CITY OF ALBUQUERQUE

**Re: Orpheum Community Hub,
500 2nd St SW
Request for Certificate of Occupancy
Transportation Development Final Inspection
Engineer's/Architect's Stamp dated 10-08-18 (K14D114)
Certification dated 4-12-19**

C101

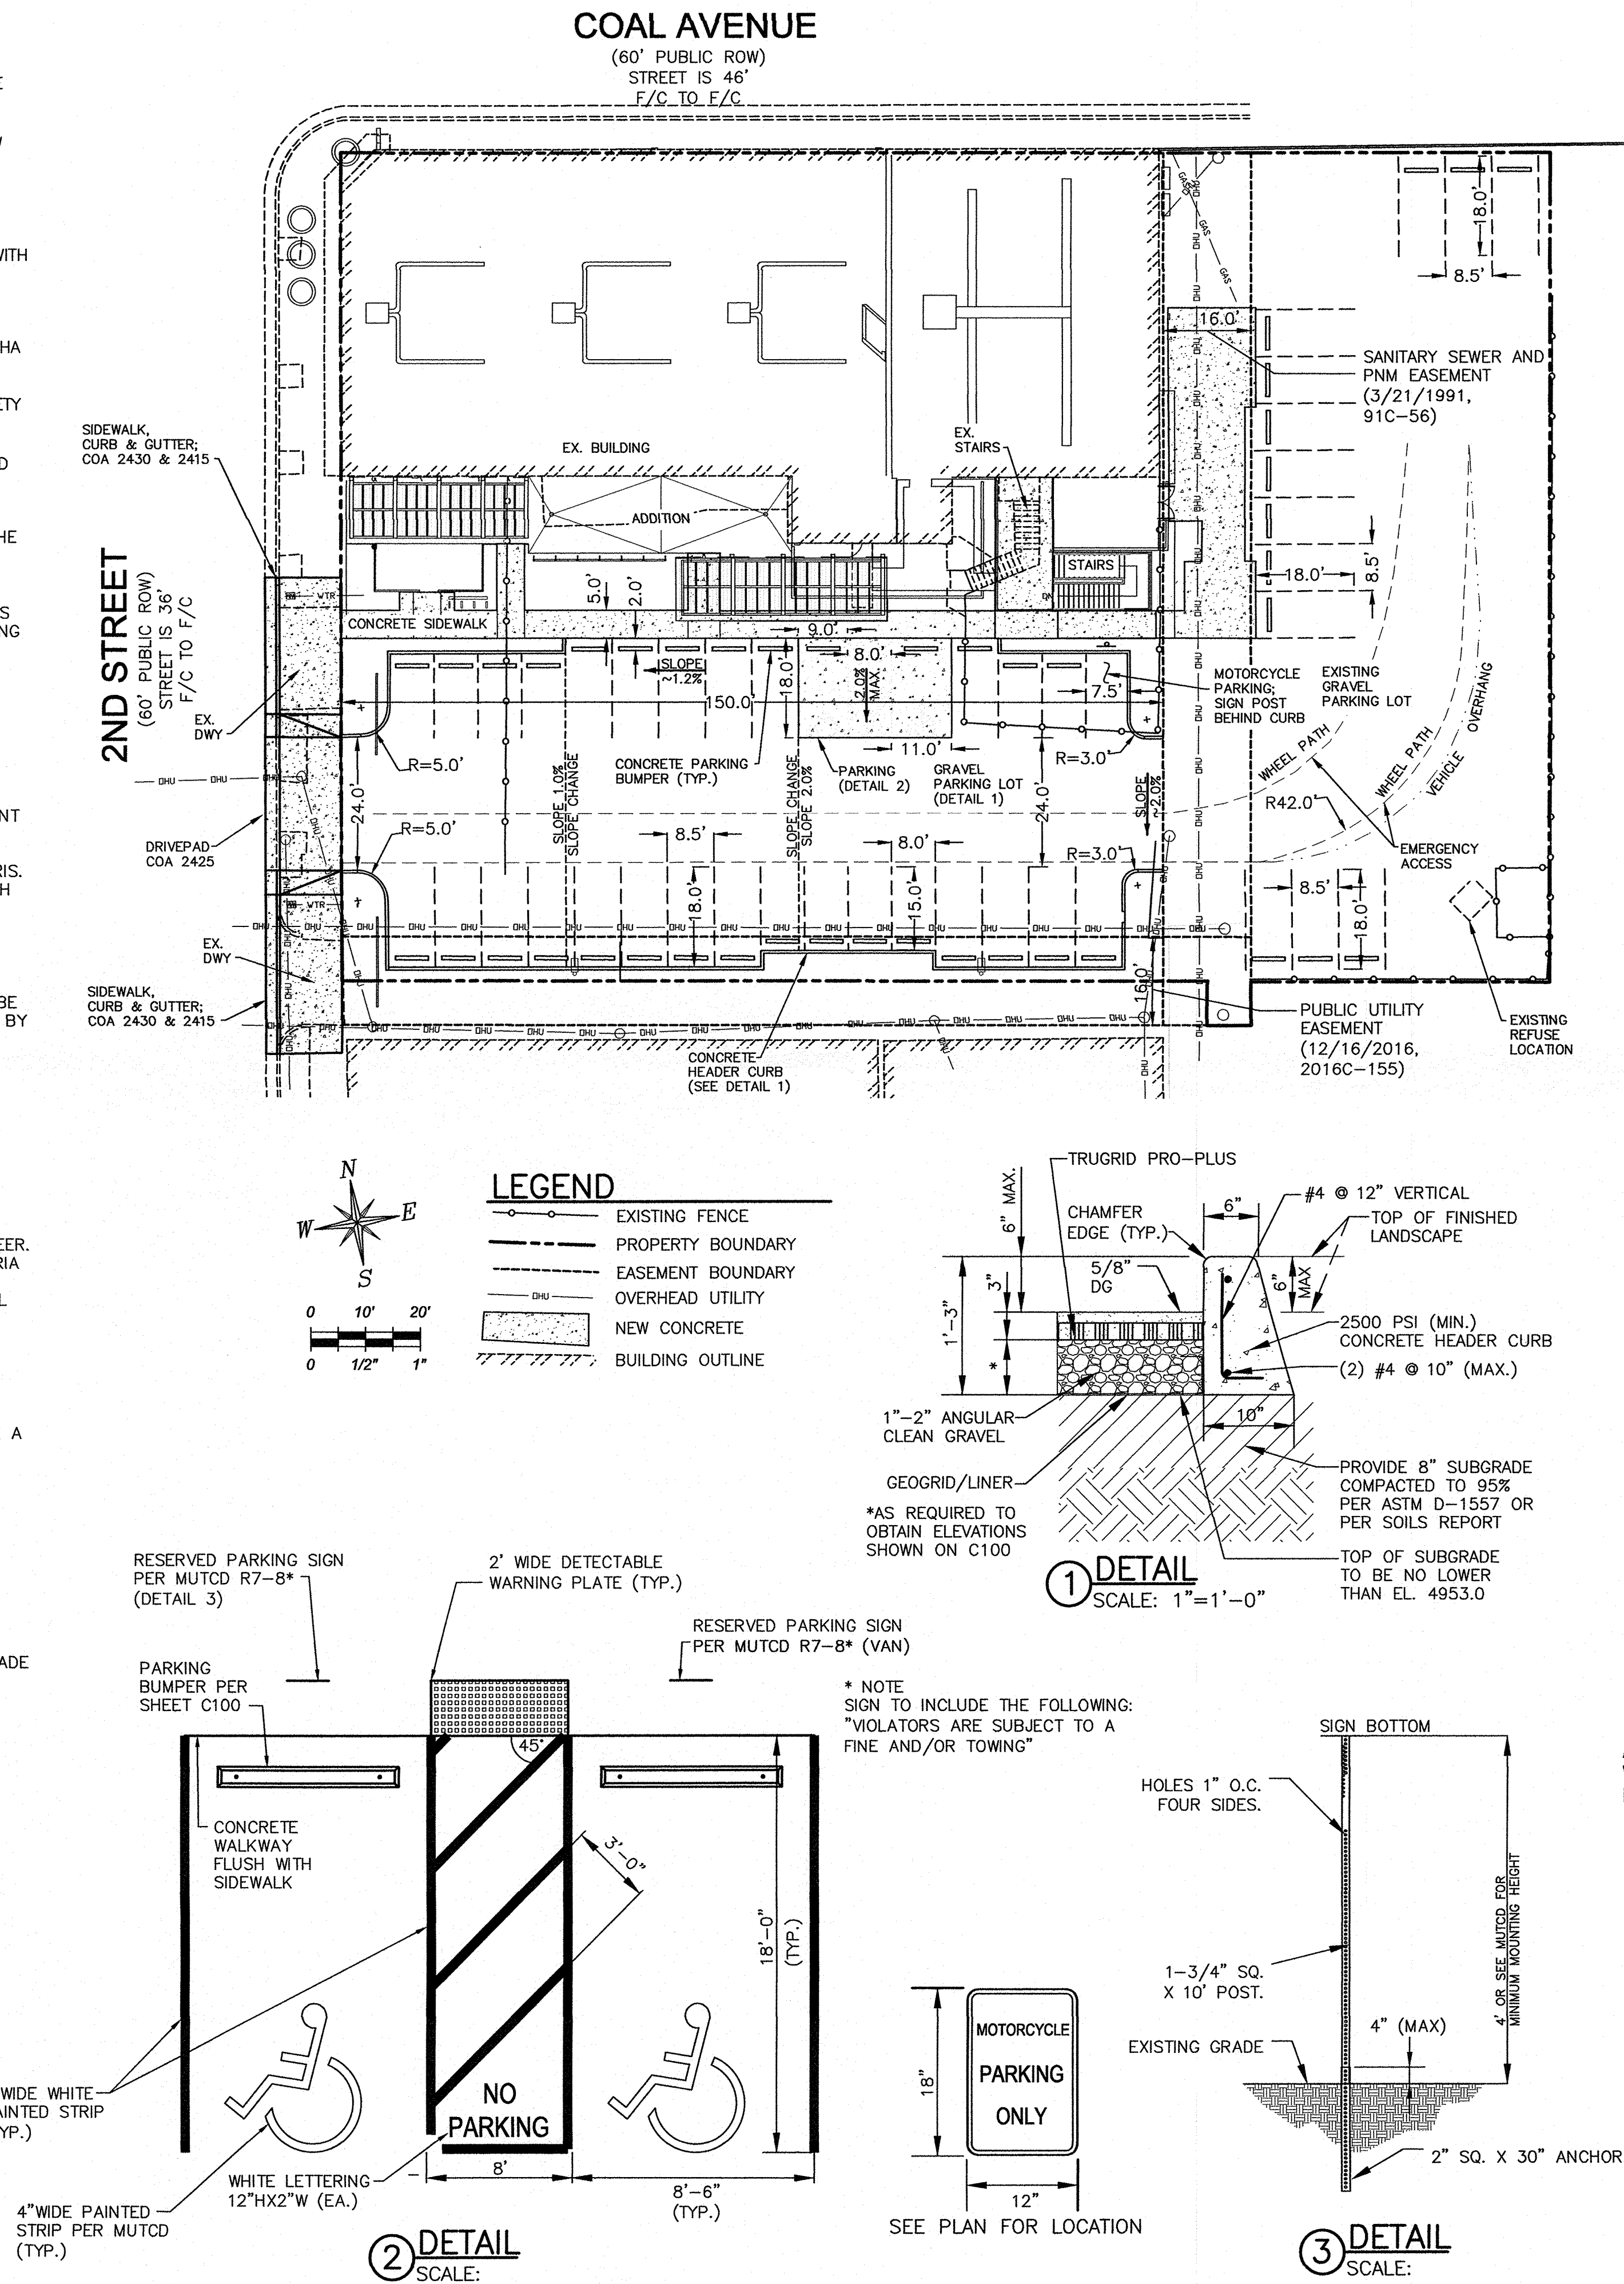
- The east parking lot needs to be Gravel according to TCL.
- The 13 spaces at the east side is missing.
- Please remove the containers from the motorcycle parking space.
- Remove all construction debris.
